Application for Listed Building Consent for redevelopment and conversion of the former Bevin Bevin site to provide 7No. apartments and 6No. houses with associated car parking

Bevin Bevin & Co Ltd River Road Arundel

Thank you for your internet representation made on 11th November 2013 which has been recorded as '**an objection**' with the comments as follows:

Drawing
Apartment 8-9, 12 & 13 Elevations
Scale: @A3
1:100

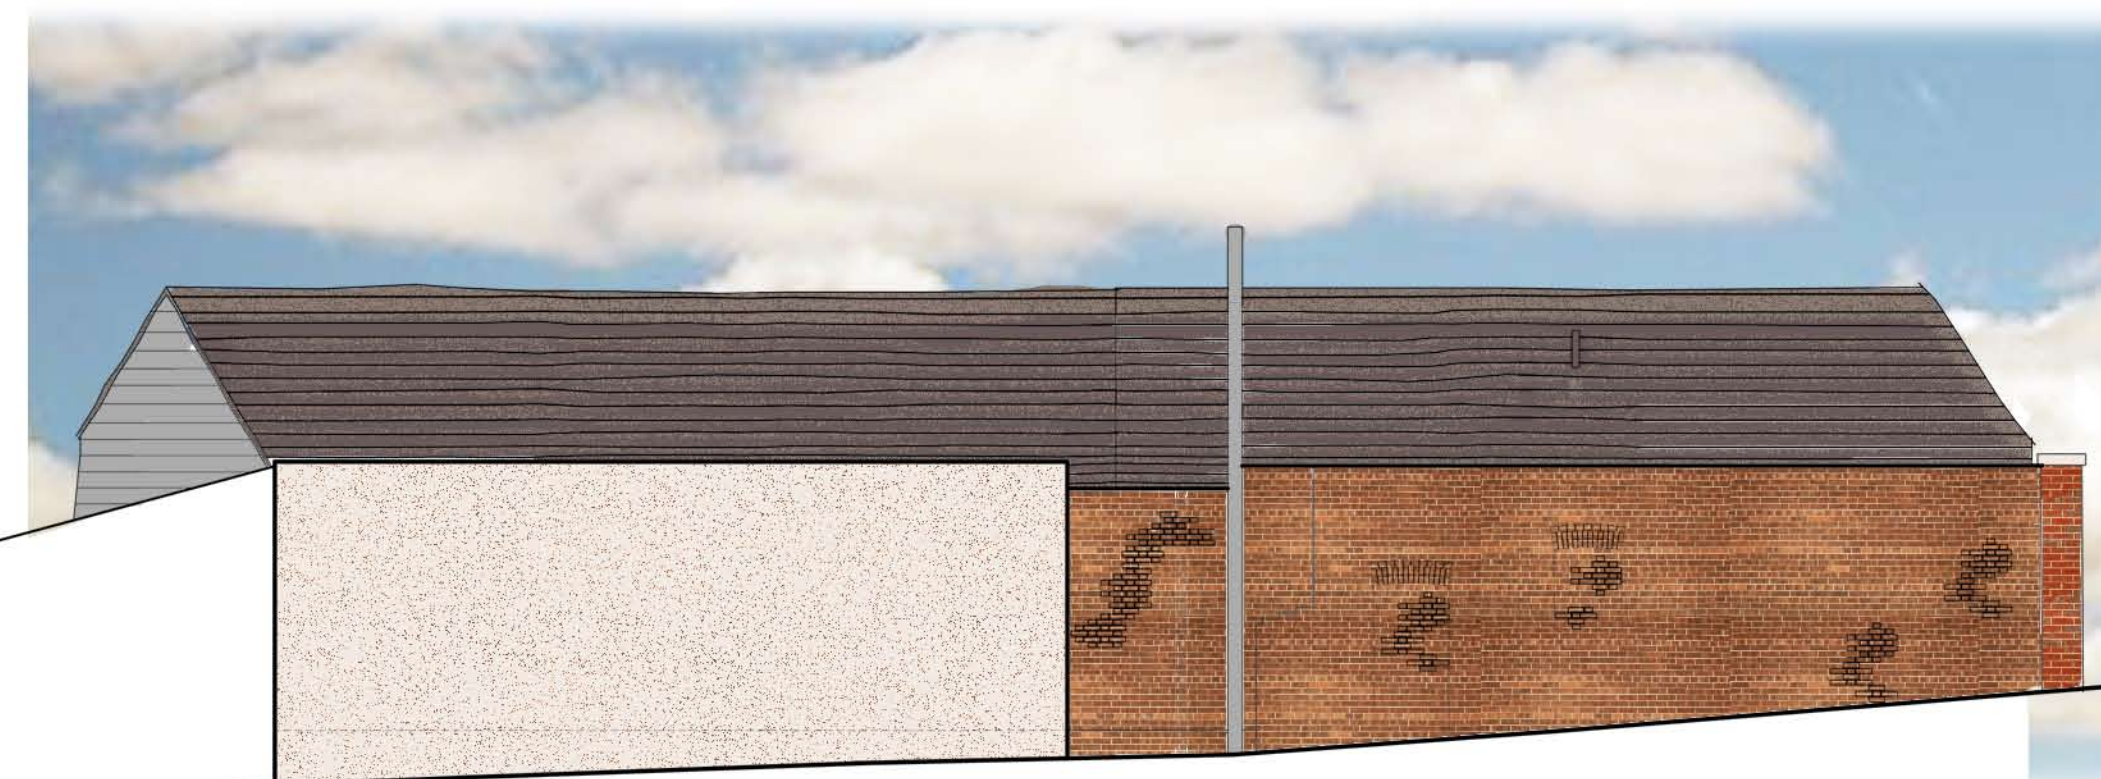
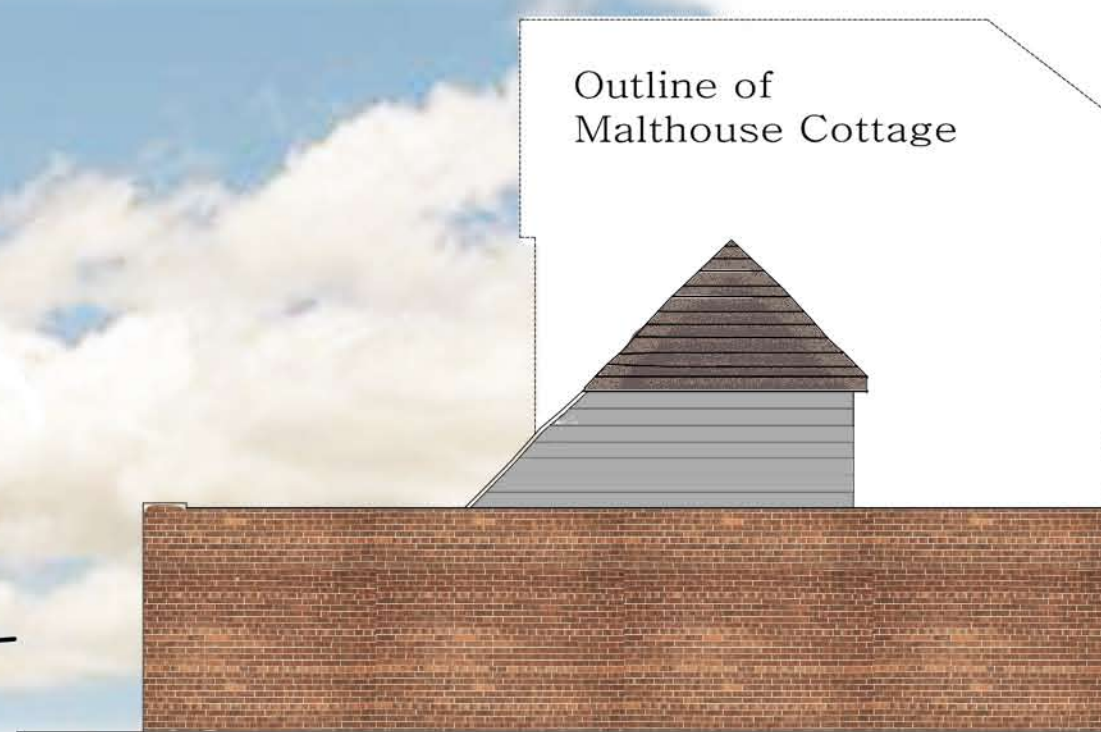
- 1. The east elevation of proposed flats Nos. 12 & 13 will be too high. These buildings will reduce light into the existing house known as Holly Tree Cottage (and the adjoining neighbour's house to the south of this).*

- 2. The outlook from Holly Tree Cottage onto that wall and the roofs of the proposed flats 12 & 13 will be dull and featureless.*
- 3. The wall (both the brick and the rendered portions of it) on the east side of the site is already excessively high, and restricts light into the house known as Holly Tree Cottage; and the redevelopment proposal misses an opportunity to create a pleasing view onto an attractive range of buildings (instead of onto a blank wall) and, from the upper floor of Holly Tree Cottage, to allow perspectives over the immediate buildings to the view beyond.*
